March 11, 2022

**Re: Albuquerque Ranch Phase 2 - 12501 Walkerway St. NE
Erosion and Sediment Control Plan
Engineer's Stamp Date (missing) (E22E002)**

James D. Hughes, P.E.
Principal Engineer, Planning Dept.
Development and Review Services

# TESCP

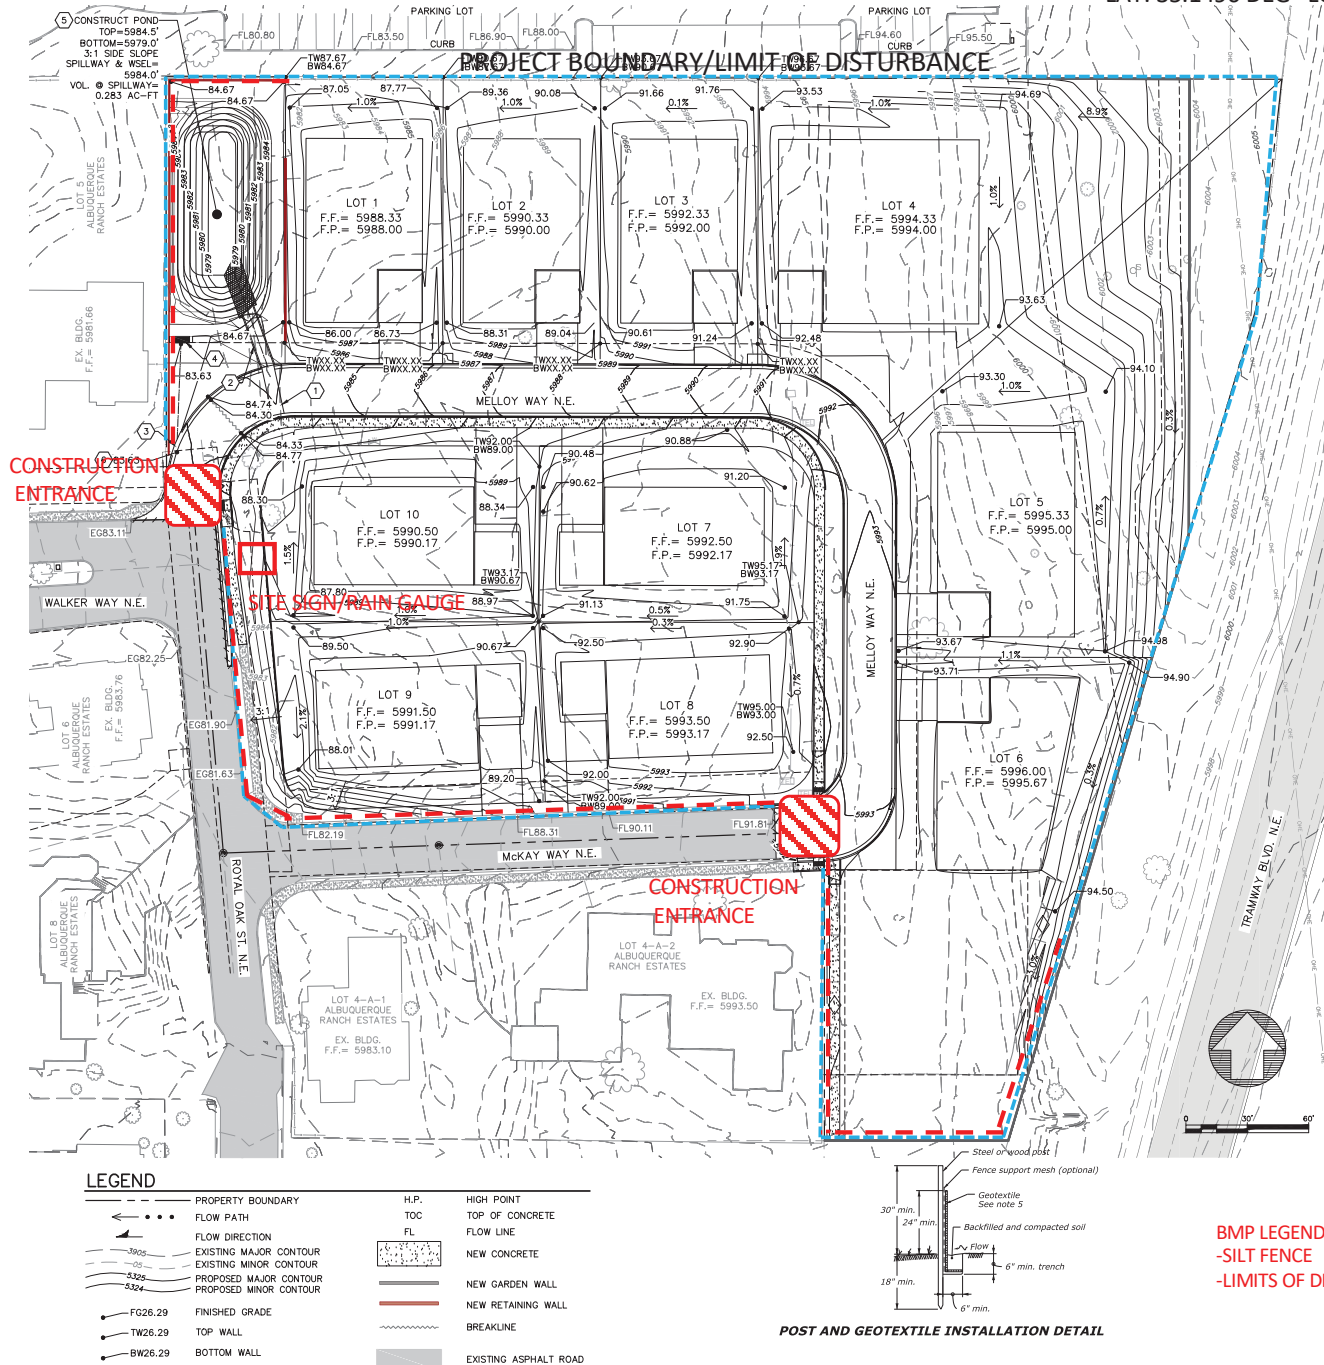
1. The professional certification is missing from the plan that was submitted. The ESC Plan must be certified by a New Mexico Registered Professional Engineer (PE) or a Certified Professional in Erosion and Sediment Control (CPESC). Update the engineer's stamp date each time the plan is changed.

2. Describe the nature and extent of construction activities (CGP 7.2.2.a) and a Project Schedule (CGP 7.2.3.f) or Sequence of Construction. Include the initial establishment of BMPs, add the pond as an initial BMP, demolition, clearing, grading utilities, paving, a new layout of BMPs to keep sediment from the lots out of the streets after they are built, and transfer of the lots to the home builders (instead of stabilization).

3. Show a second BMP layout with silt fence around the low side of each finished lot to keep sediment out of the street to be maintained by the developer, 505 Solutions, until transferred to the home builder(s).
